**Application by Thurrock Power Limited for an Order Granting Development Consent for the Thurrock Flexible Generation Plant project.**

**The Examining Authority's Additional Written Questions and Requests for Information (ExQ3)**

**Issued on 9 July 2021**

Thurrock Flexible Generation Plant
 Access, Rights of Way and Traffic Regulation Plans
 Sheet 2 of 5

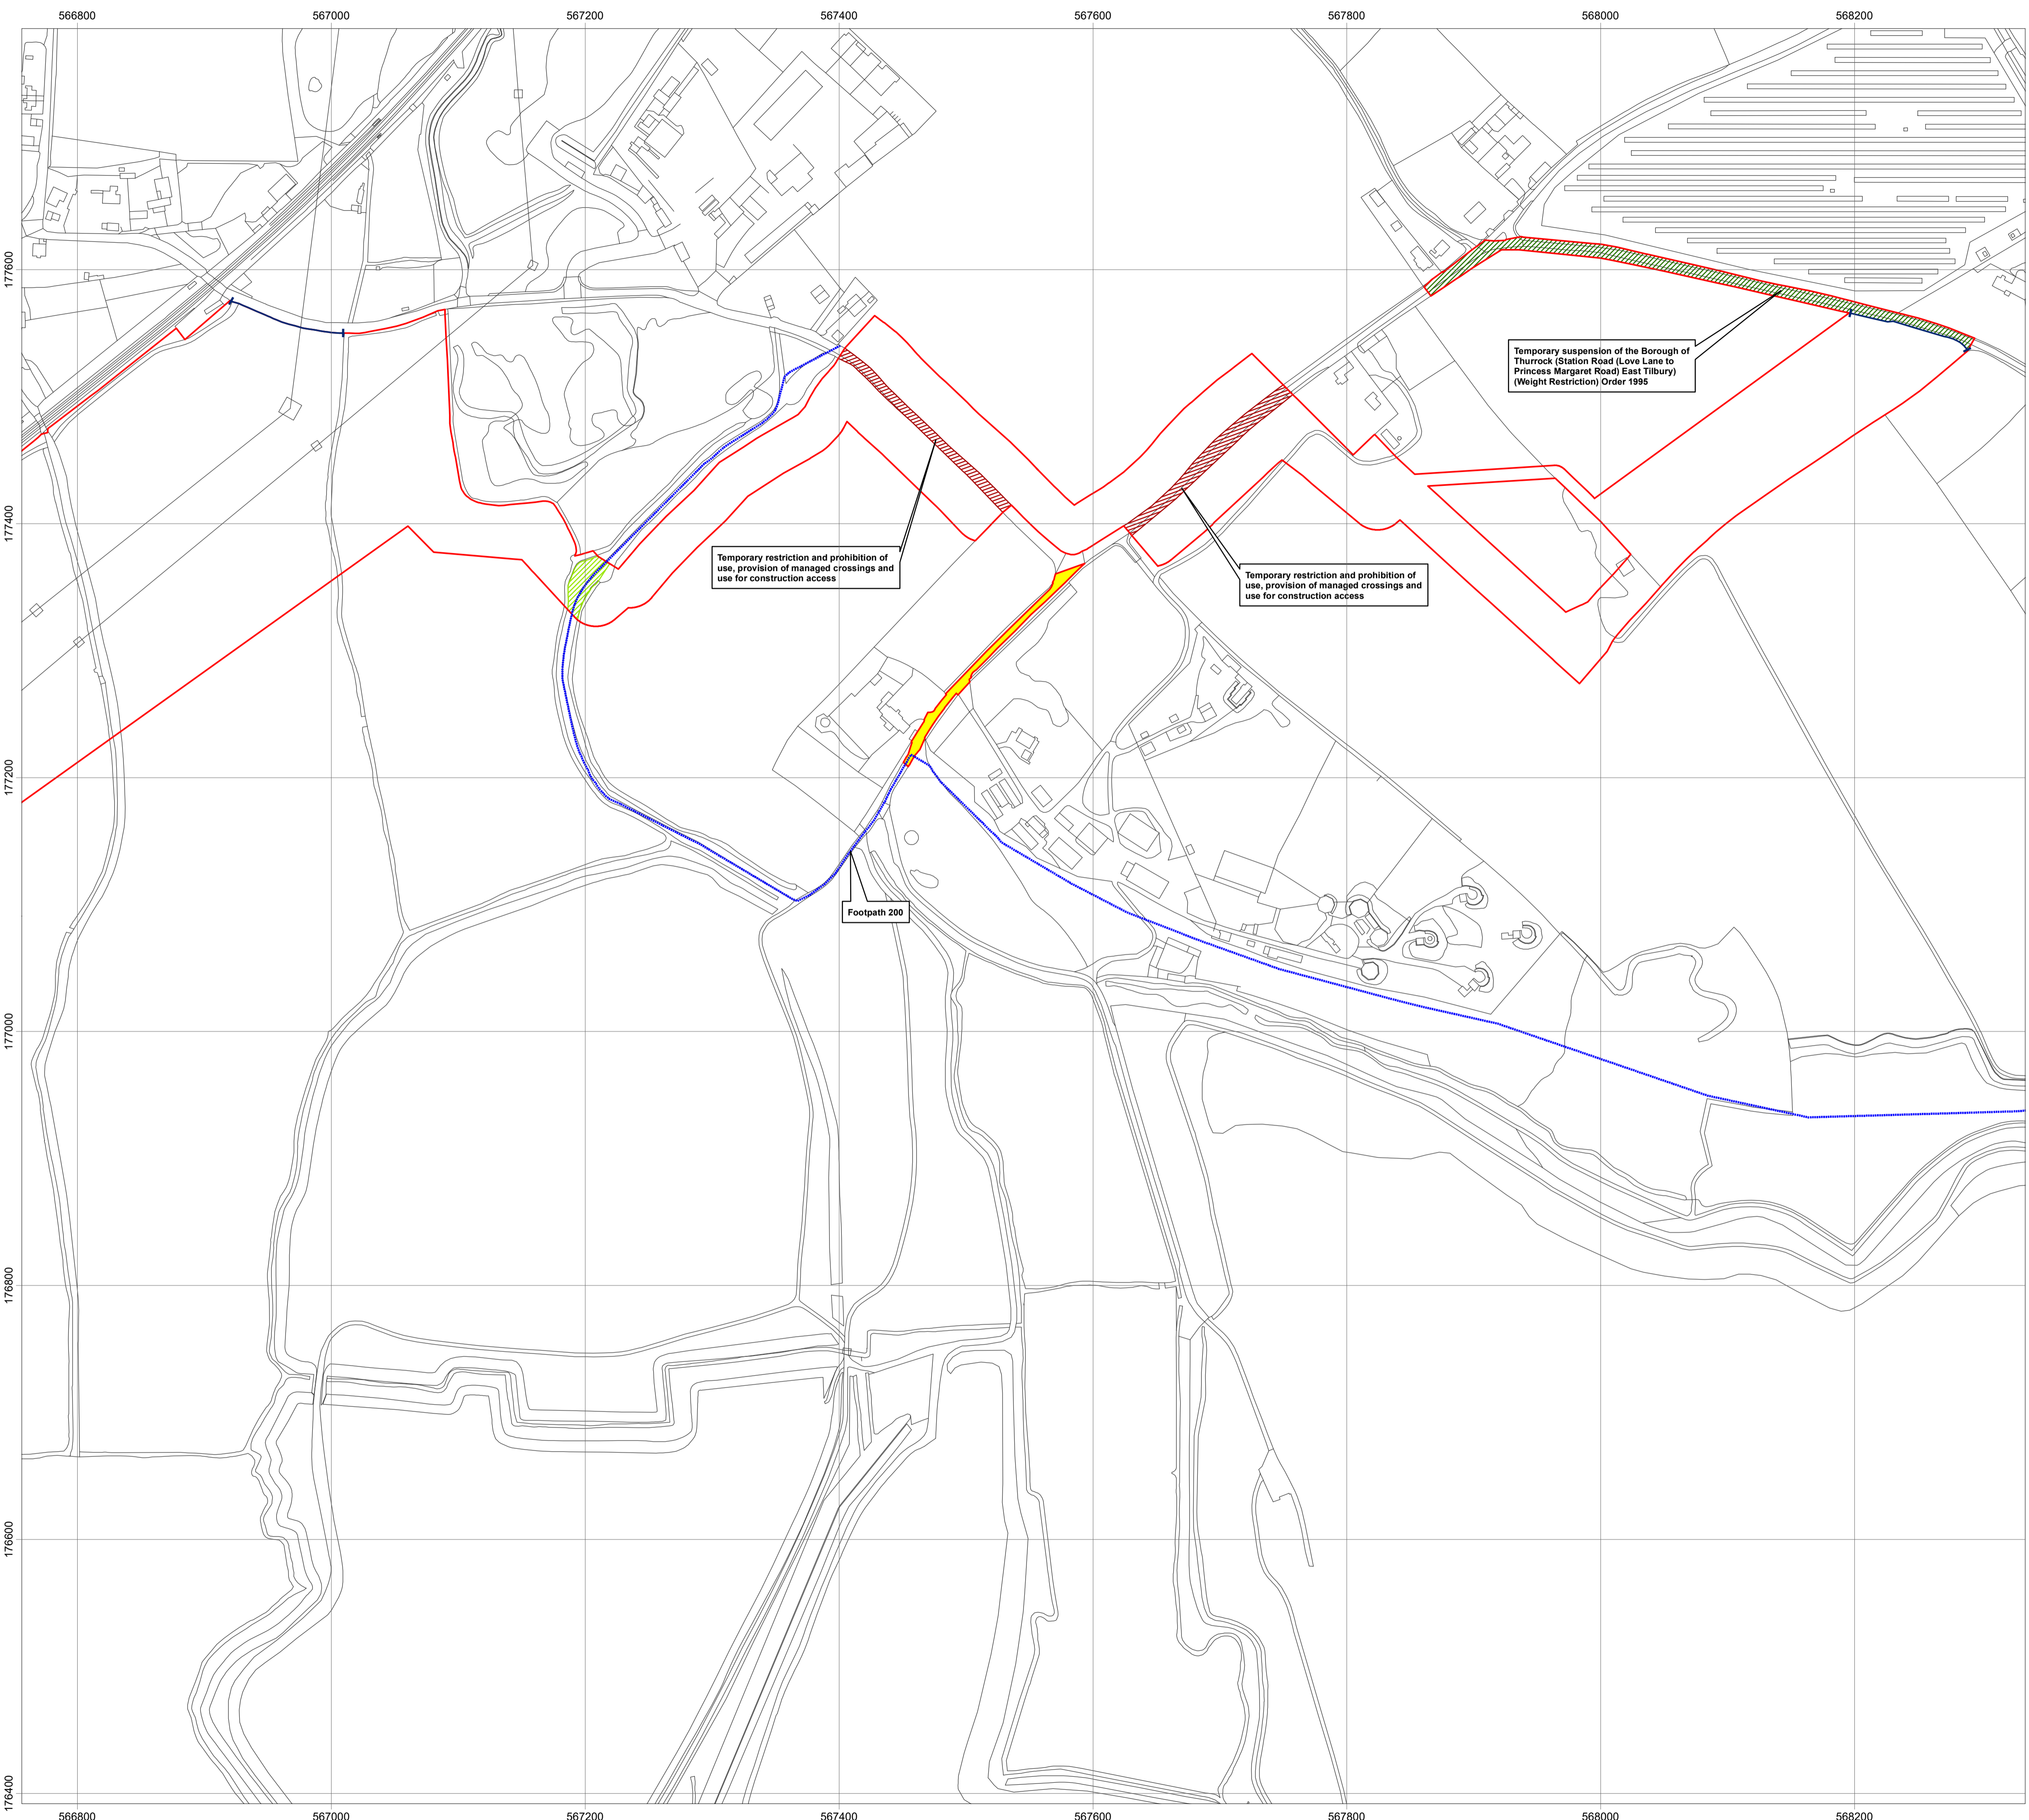
<b>ExQ.</b>	<b>Respondent:</b>	<b>Question:</b>
<b>4</b>	<b>Habitats and Onshore Ecology</b>	
3.4.1	Applicant/NE	Please provide an update on the discussions between the Applicant and NE in relation to HRA matters and water vole translocation.
3.4.2	Applicant	Please respond to the concerns raised by NE in relation to the replacement common land as set out in [REP5-027].
<b>5</b>		
3.5.1	NE	Please provide details of any comments in respect of noise impact thresholds by Deadline 6 to ensure that there is sufficient time for the Applicant and other IPs to comment before the close of the Examination.
3.5.2	Thurrock Council	Does the council consider there is a credible risk that anti-social or criminal activity could occur at the proposed footbridge and path, or the Exchange Common Land, as a result of the proposed permissive access from Fort Road?
